Application by Five Estuaries Offshore Wind Farm Limited for the Five Estuaries Wind Farm

The Examining Authority's written questions and requests for information

Issued on 8 October 2024

Title
**FIVE ESTUARIES WIND FARM
ONSHORE SUBSTATION
ELEVATIONS OF SUBSTATION
COMPOUND- AIS OPTION
Sheet 01 of 01**

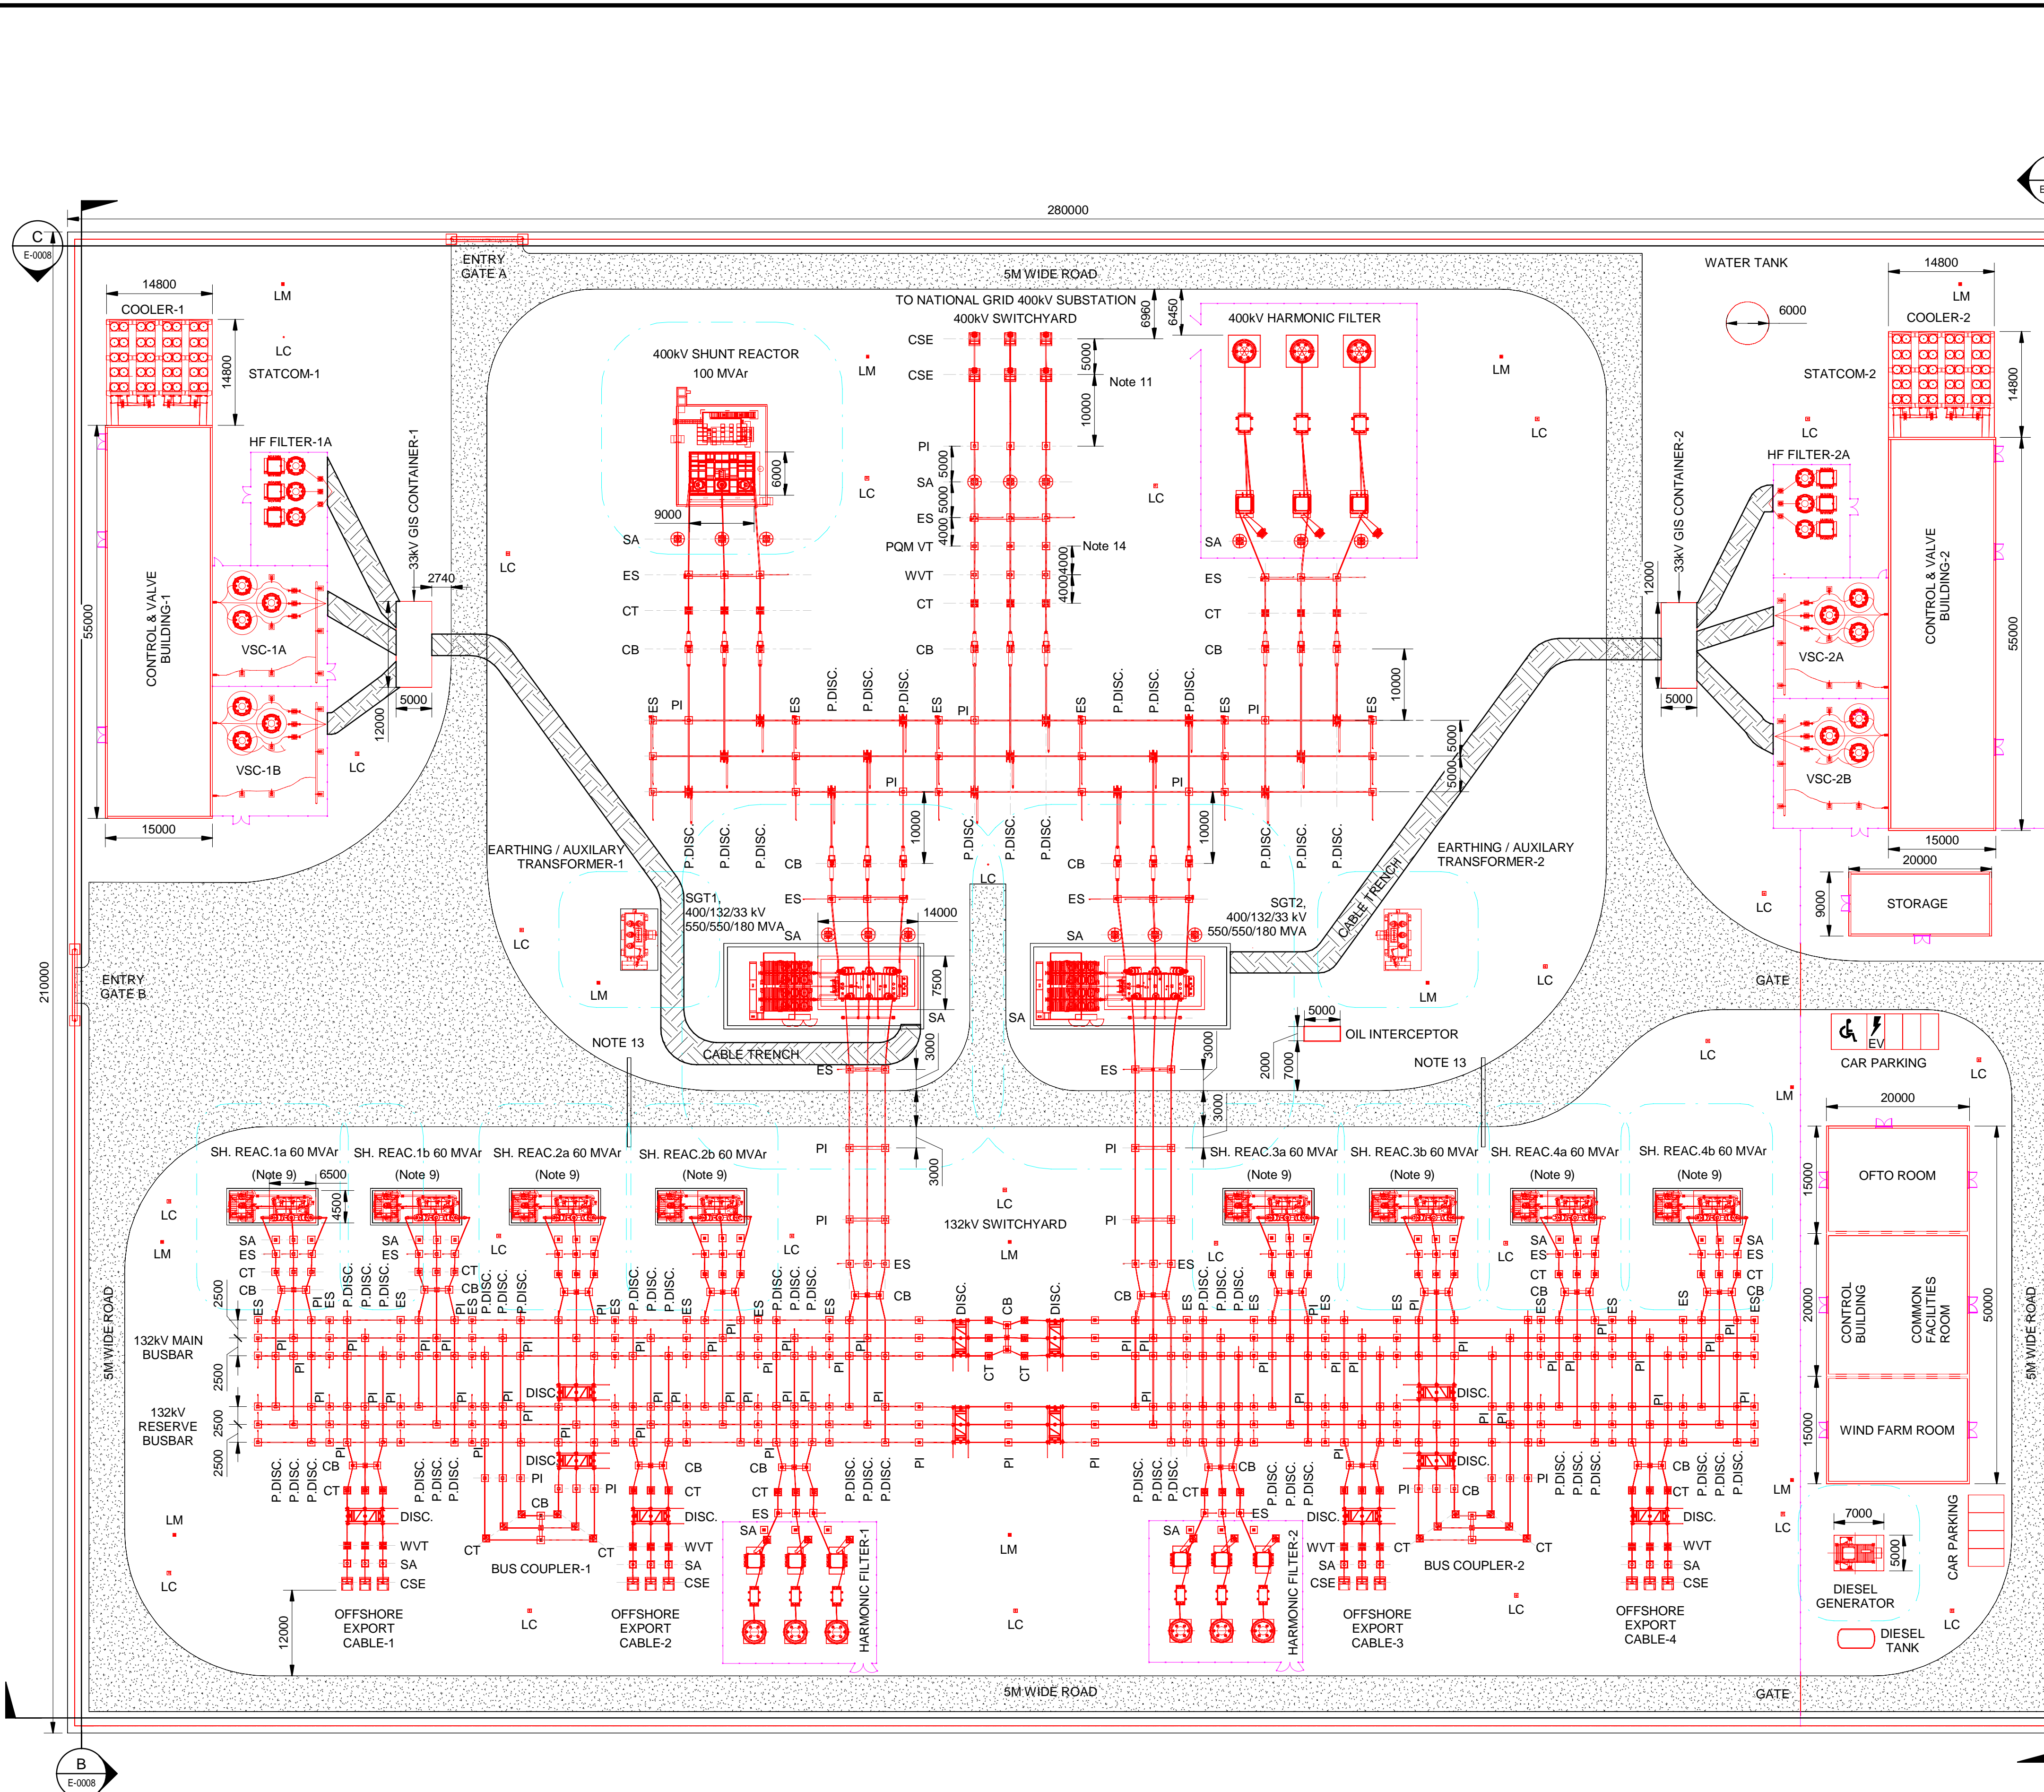
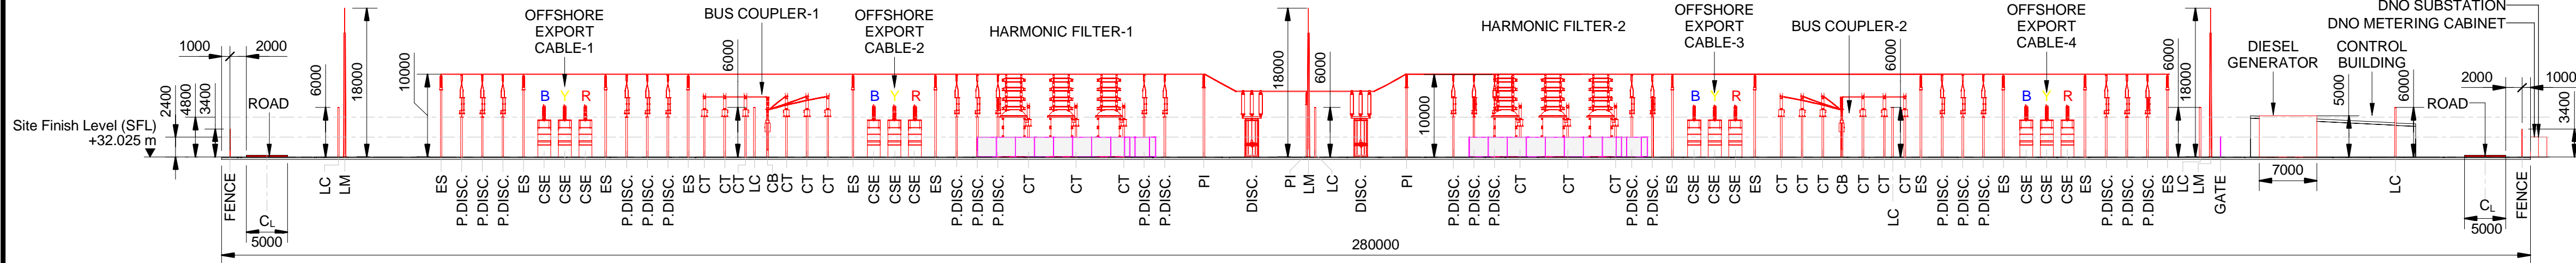
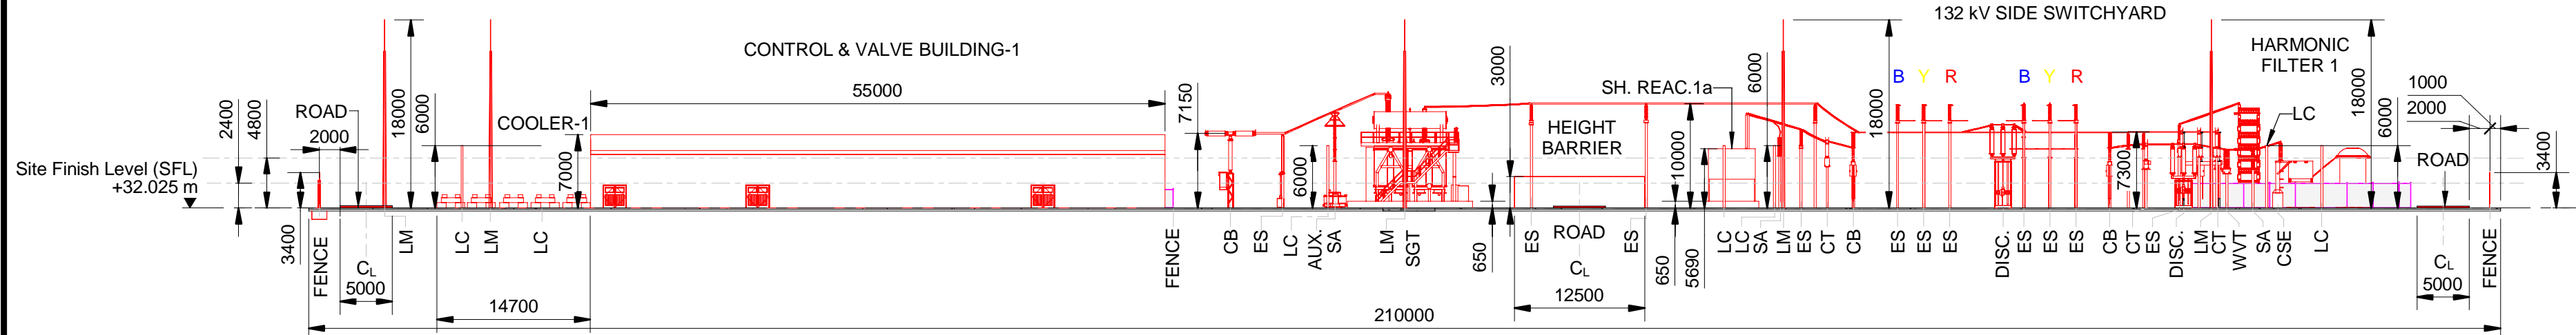
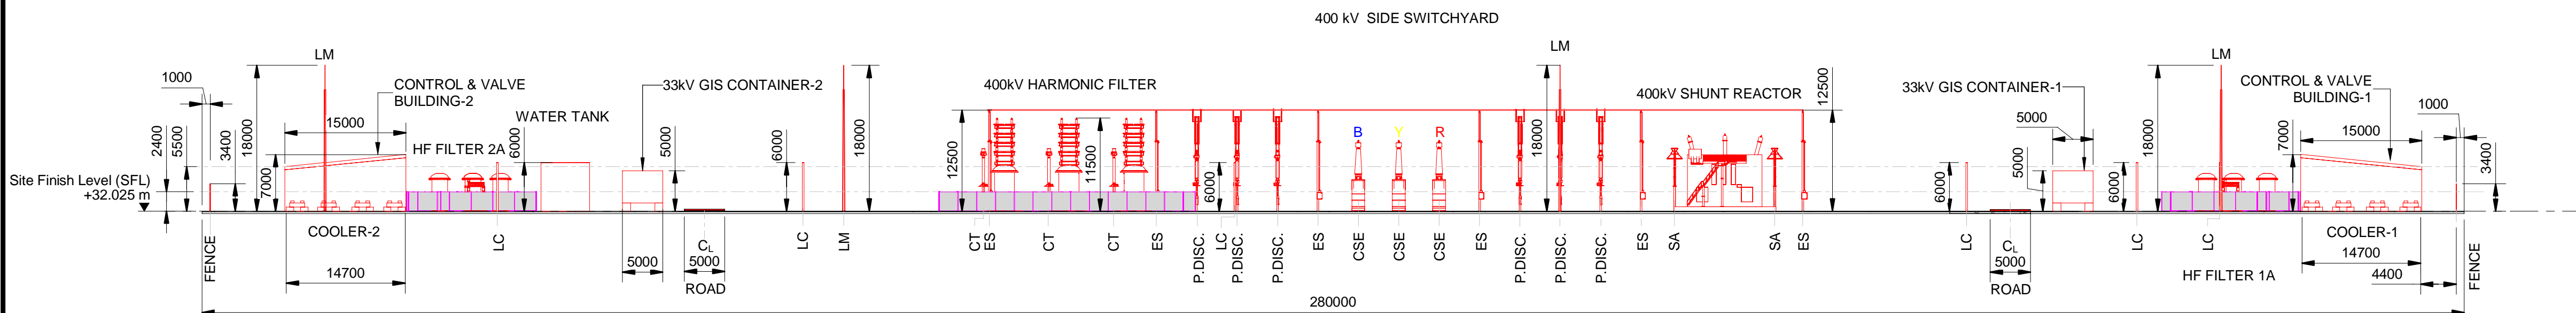
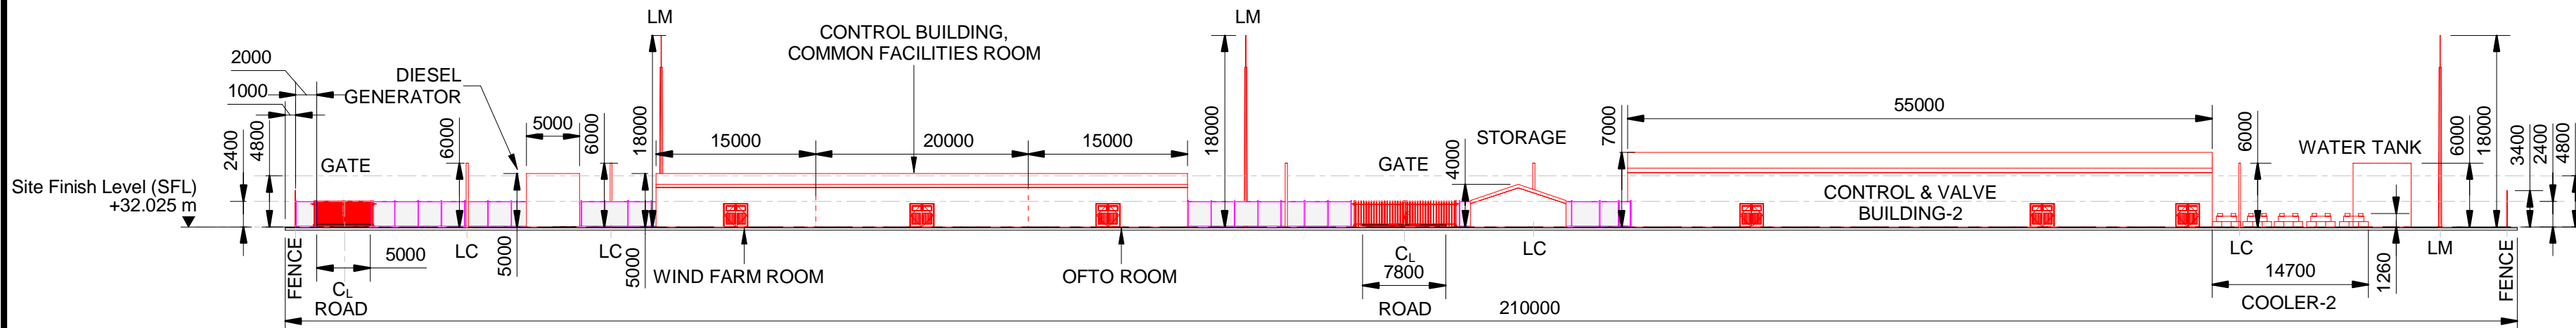
Question to:	Question
GC.1.15	Applicant	<p>Designing the proposed onshore substation</p> <p>Section 2.3 of the onshore substation design principles document [APP-234] refers to a design review process being used to finalise the design for the proposed onshore substation. Who would be the “<i>Project Design Champion</i>” and who would be the members of the “<i>Design Review Panel</i>”?</p>
GC.1.16	Applicant	<p>Onshore substation design principles</p> <p>In terms of selecting a location for the proposed onshore substation, paragraph 3.2.5 of the OnSS design principles document [APP-234] refers to, amongst other things, “<i>The Horlock Rules</i>”. What are the Horlock Rules. In answering this question a copy of the Horlock rules should be submitted.</p>
GC.1.17	Applicant	<p>Offshore Decommissioning</p> <p>Within the Application documentation it is submitted that the effects associated with the decommissioning of the offshore works would be similar to the offshore construction works for the Proposed Development, is that proposition correct? For example, would the process of dismantling the wind turbine generators, including removing their piled foundations, have effects for marine ecology similar to those associated with the undertaking of piling and the pouring of concrete?</p>
